NFPA LIFE SAFETY CODE -- FIRE PREVENTION CODE
DWELLING UNIT COMPLIANCE

Location: 16 William St.

Number of units to be legalized: 1

16 William St.

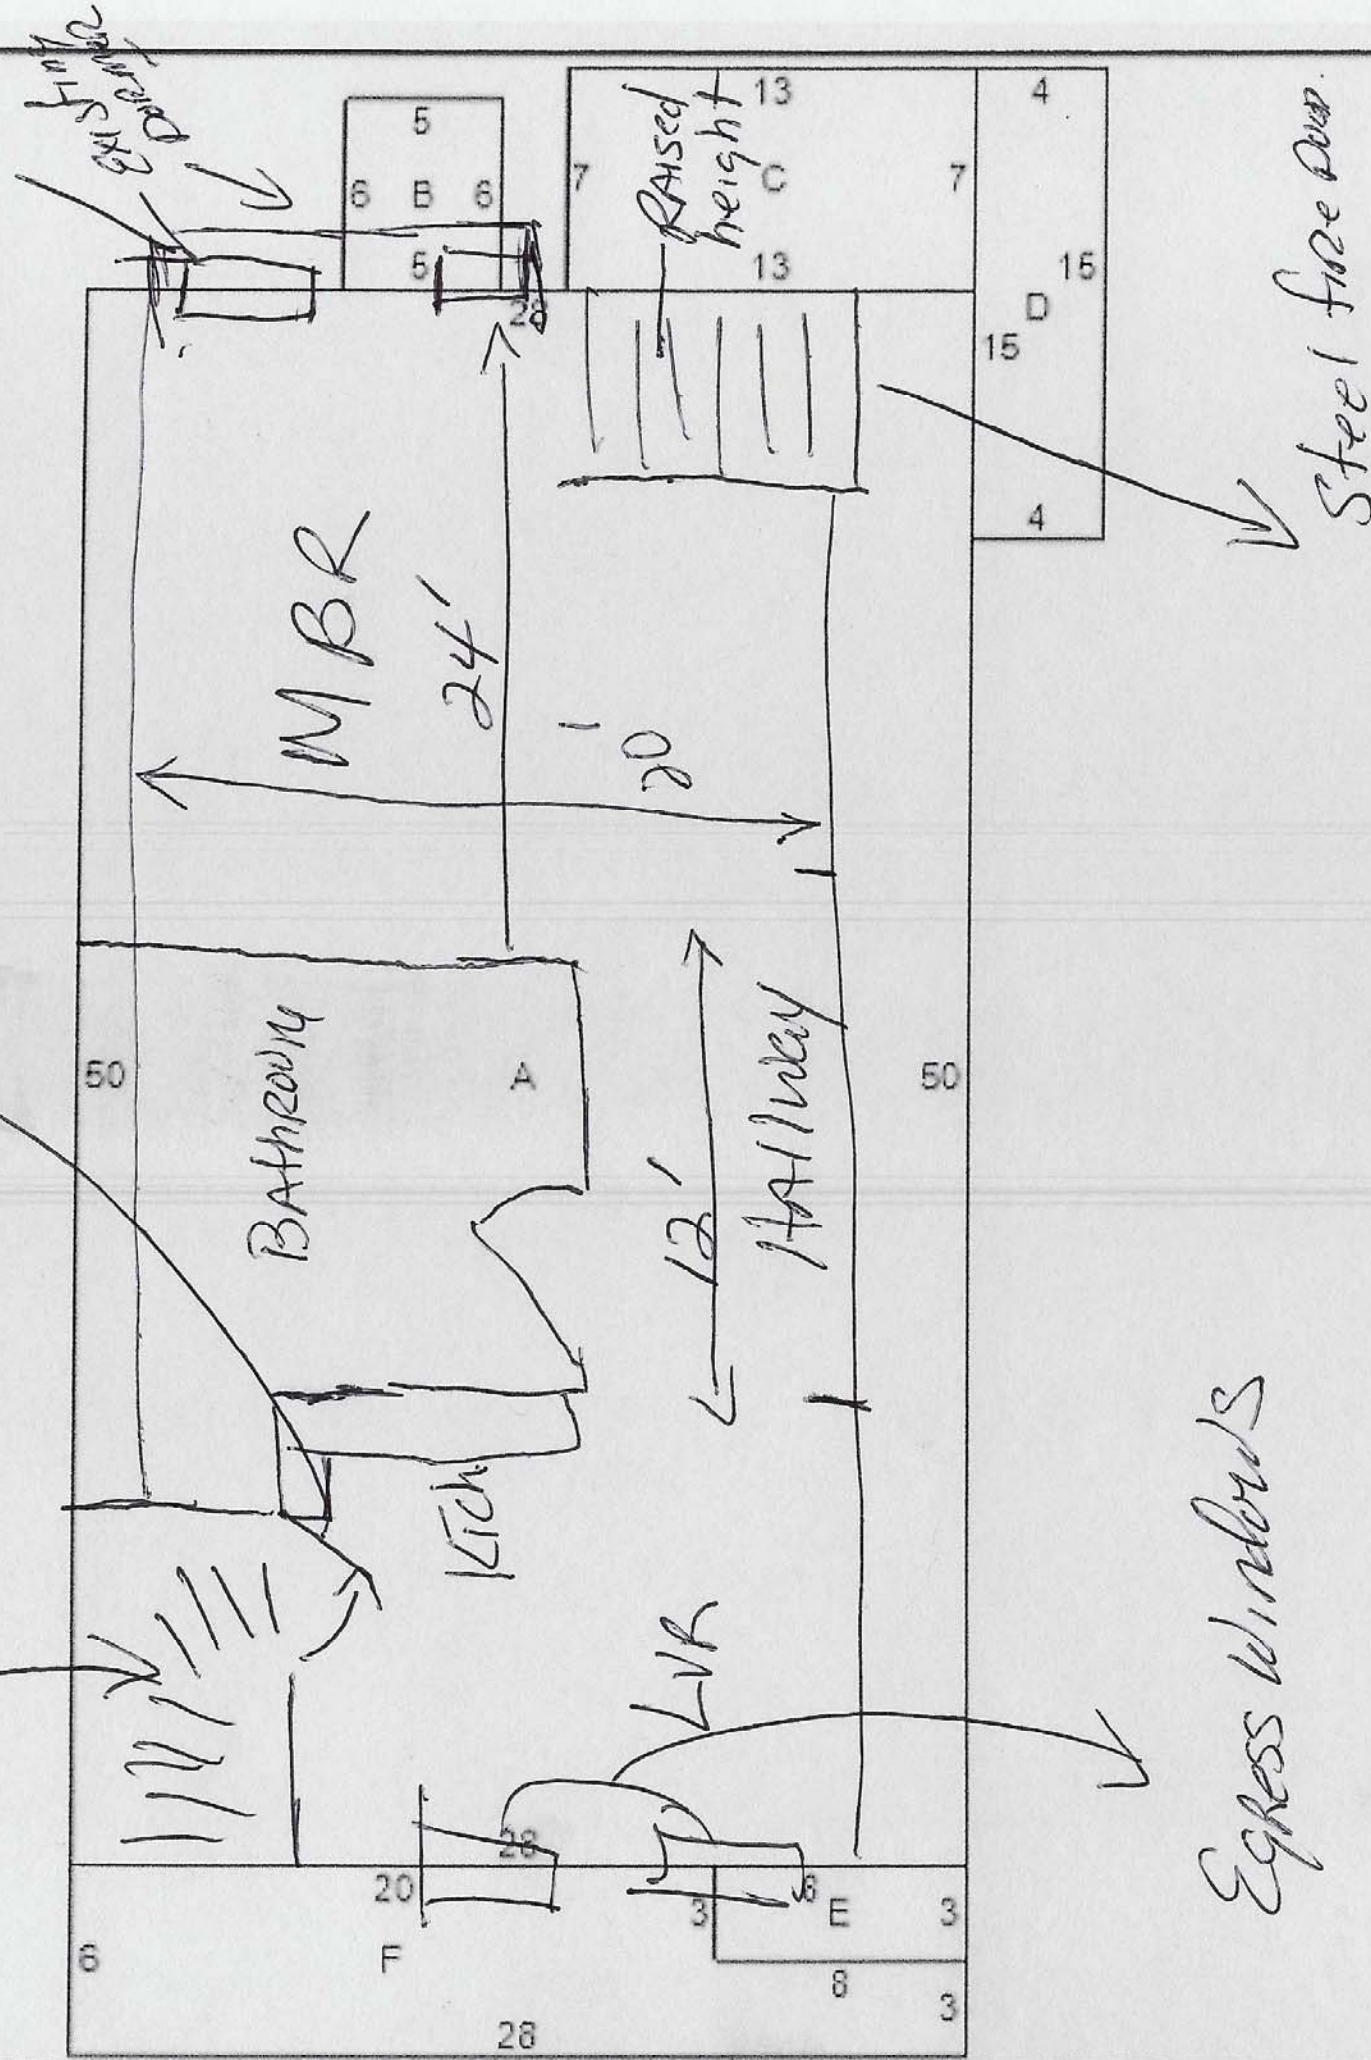
Sprinkler protection over boiler
smoke/CO combo. basement & 3rd floor > Complete 7/27/16
outlet covers required Chasements
